From: Richard Castro-Parker
Sent: 19 August 2019 16:17
To: Samantha Lee
Cc: Daniel Vick
Subject: FW: BE/139/18/PL - Innovation Centre Beeding Close
Attachments: RE: BE/139/18/PL - Innovation Centre Beeding Close

Further to our telephone calls today, I had already asked the Laura Gibbons about the drainage matters you raised (see my email below). Laura has commented and has requested the following:

- Proposed Drainage Layout – 1:100 Scale;
- Proposed Drainage Layout – 1:400 Scale.

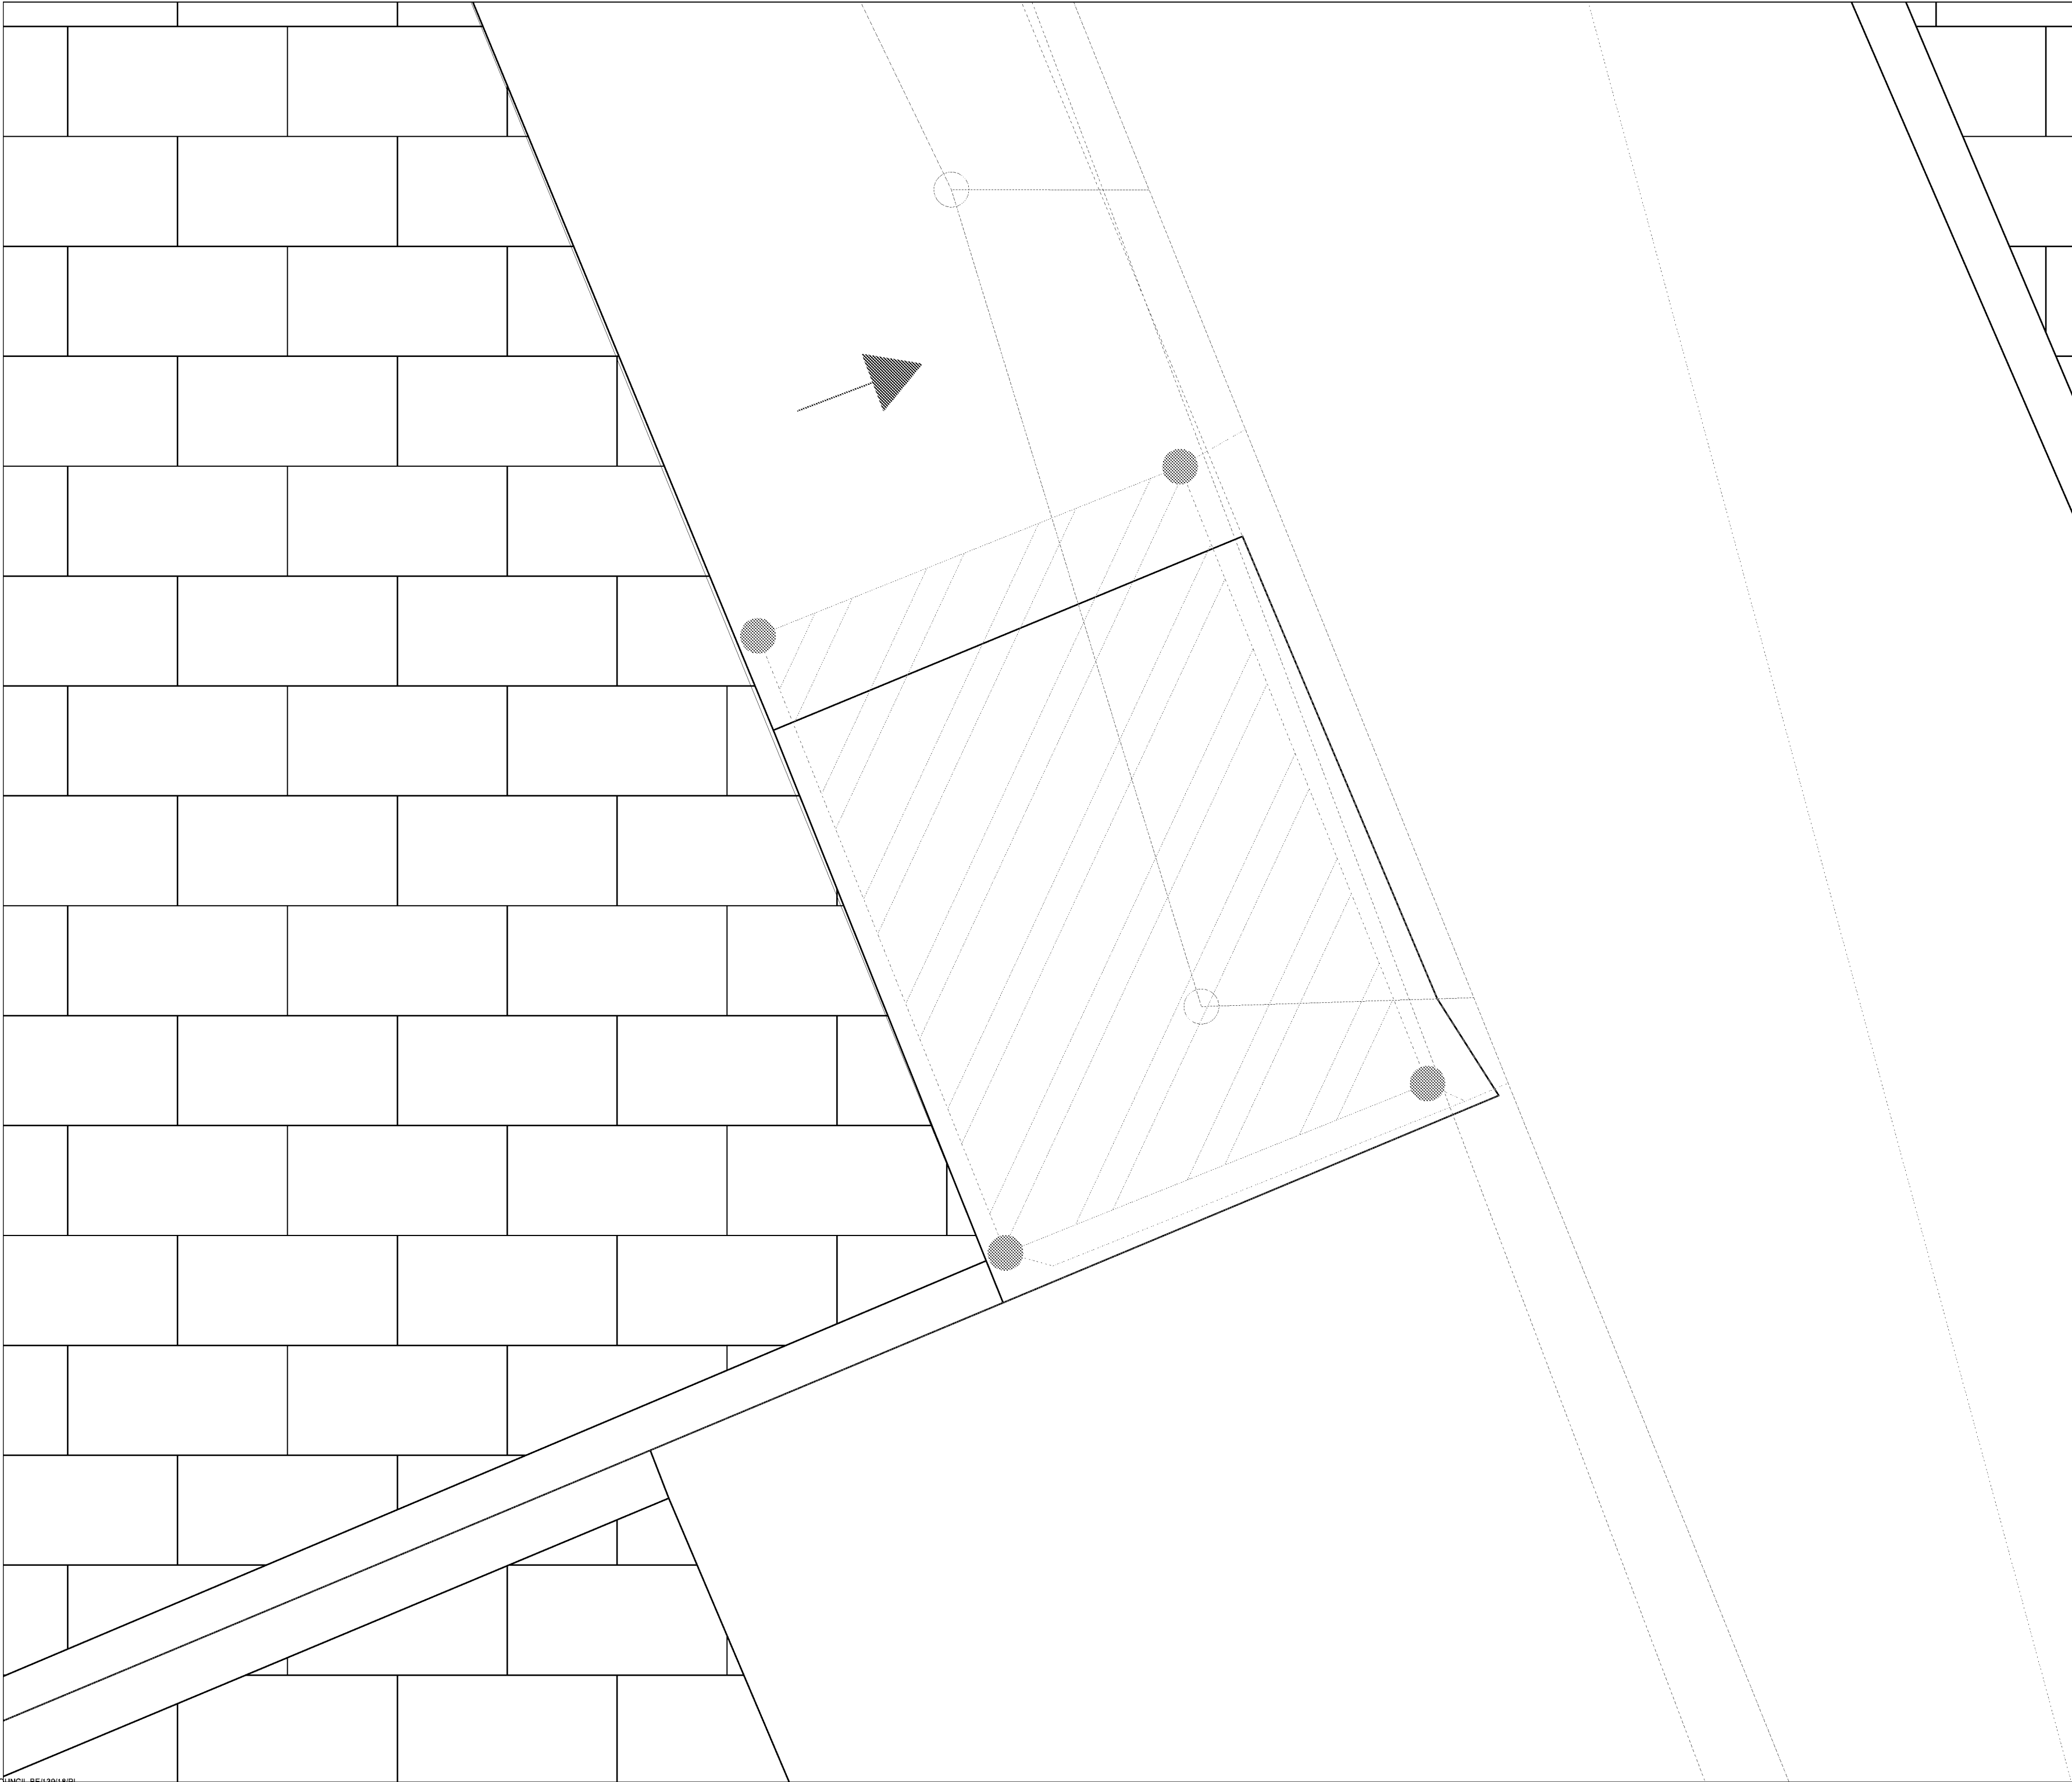
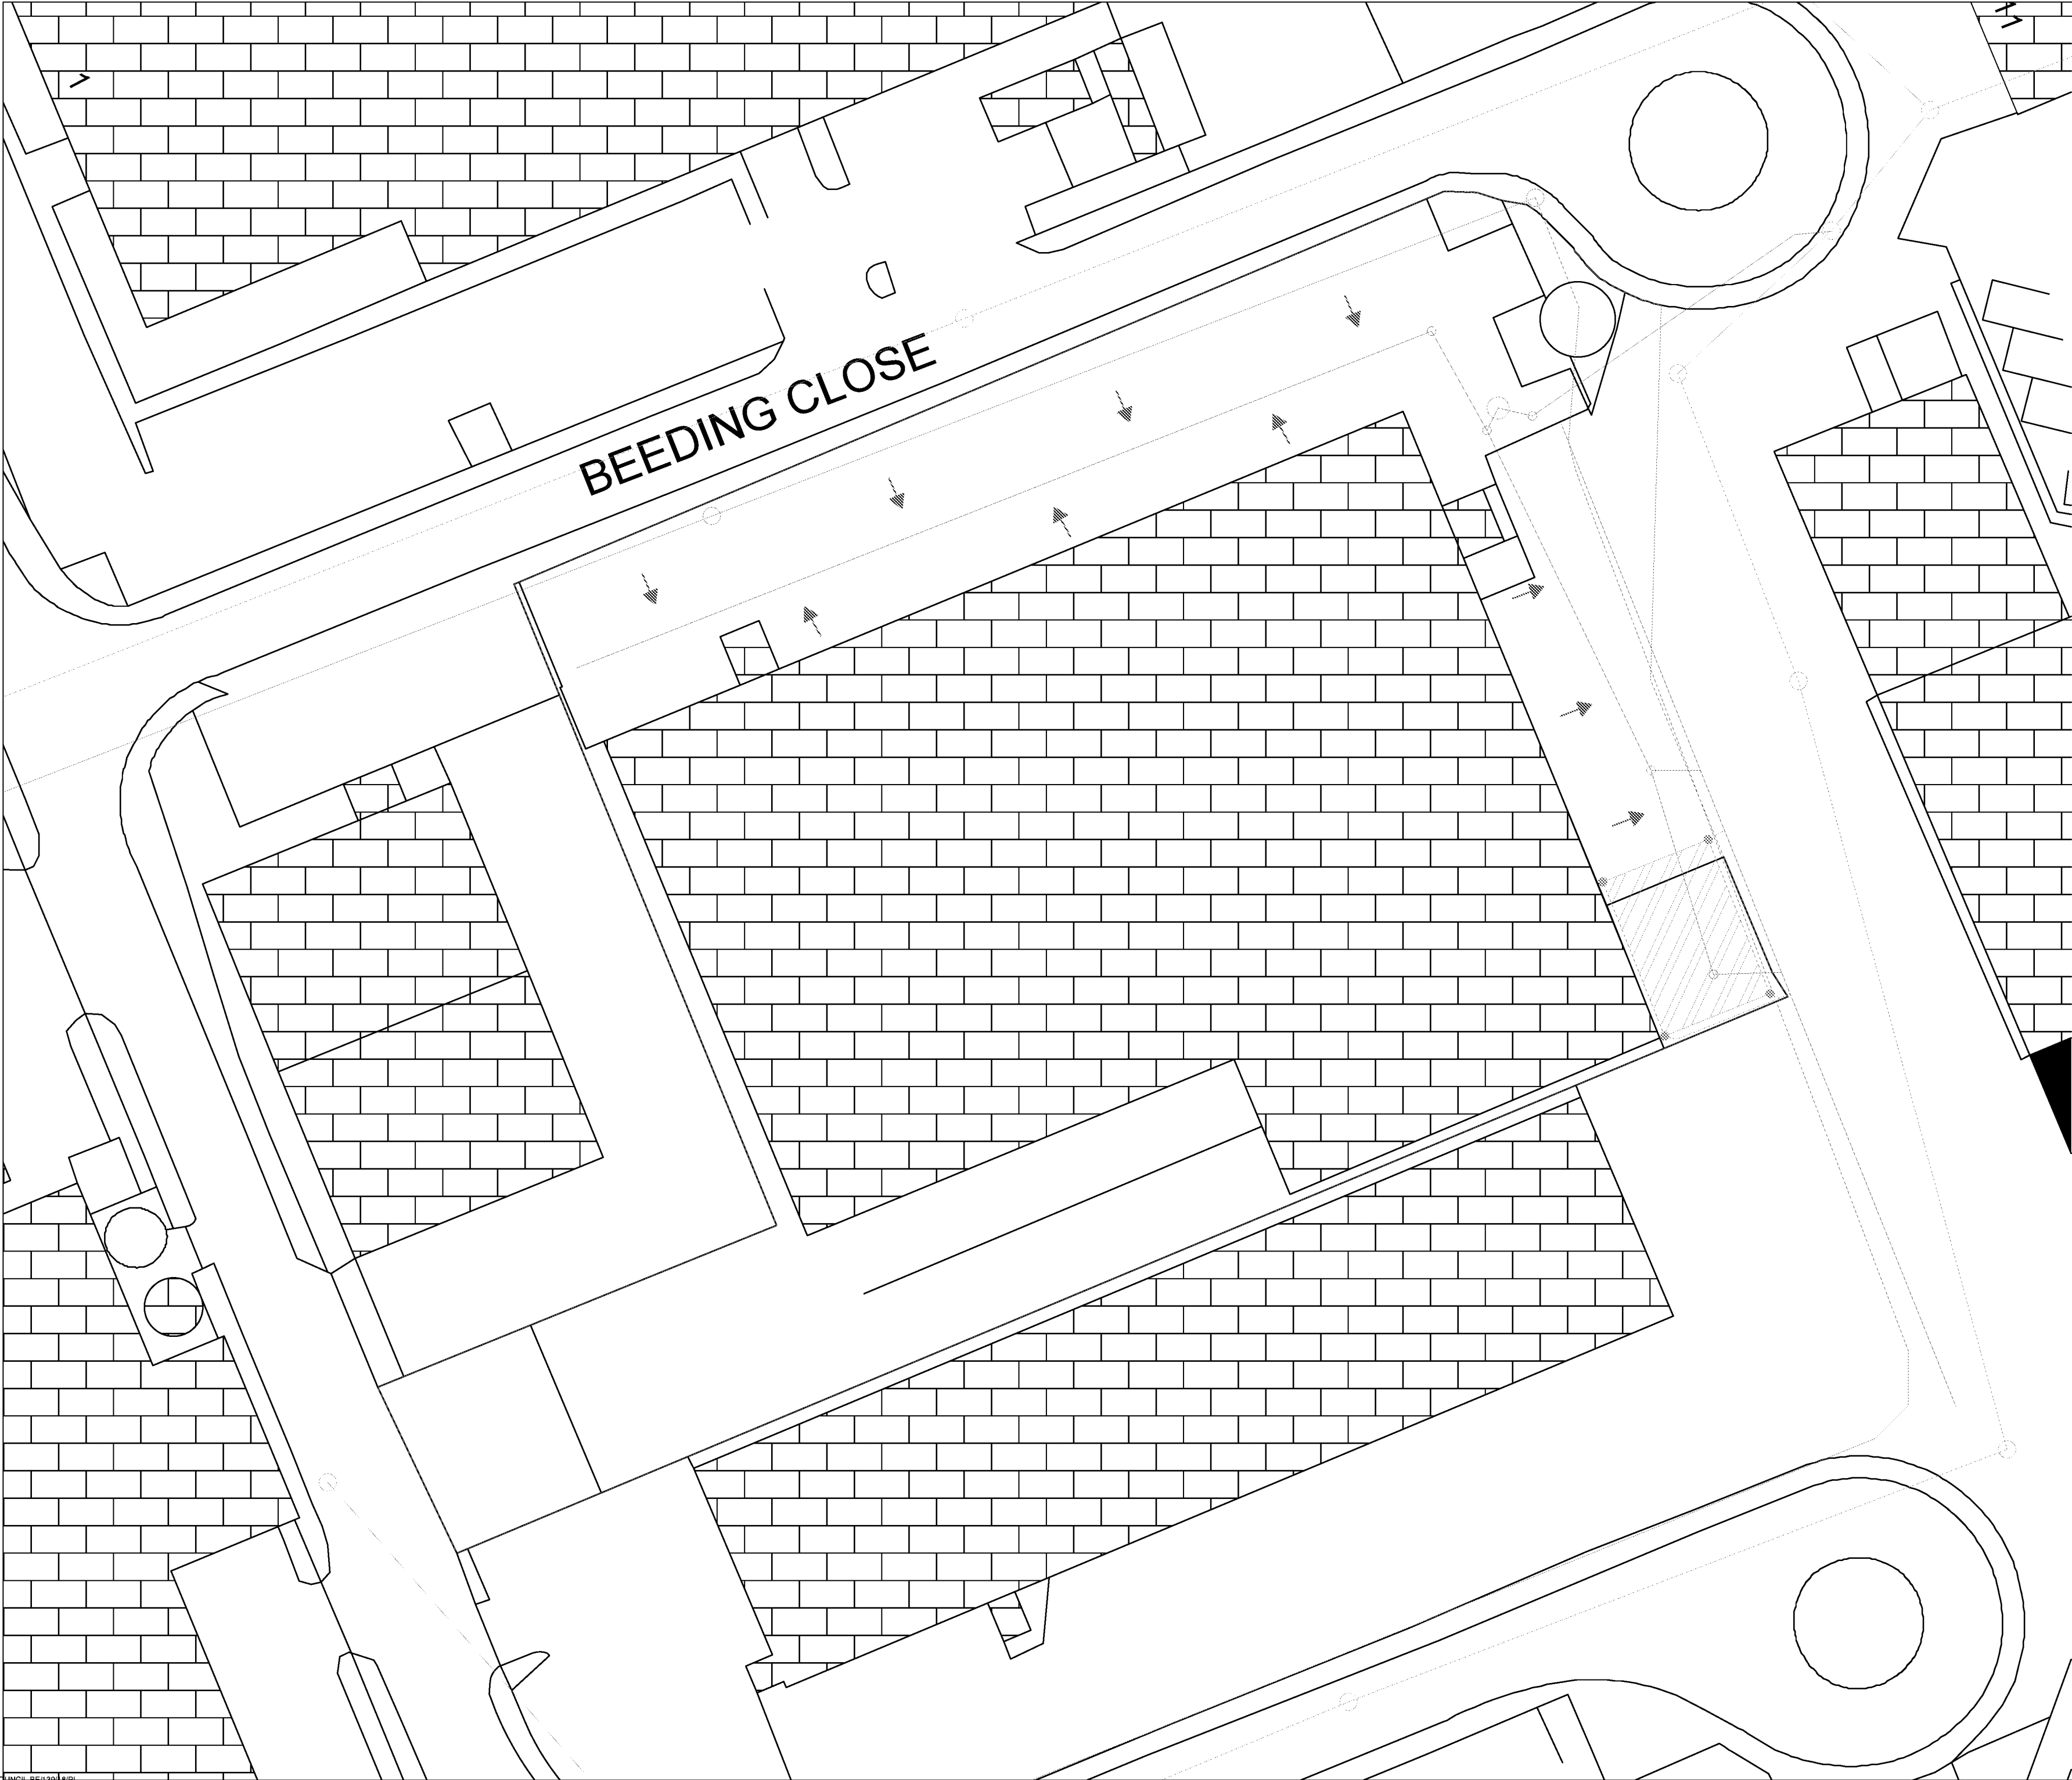
Please can the applicant submit clearer plans of the proposed surface water drainage arrangement. I.e. different line types used, rather than all very similar colours. Please can gullies, manholes, and linear drainage channels be clearly labelled.

I also require levels to be submitted showing invert and cover levels of the existing drainage network and spot levels of the surrounding land. This is fundamental to ensure that the surface water from the development does not go off site.
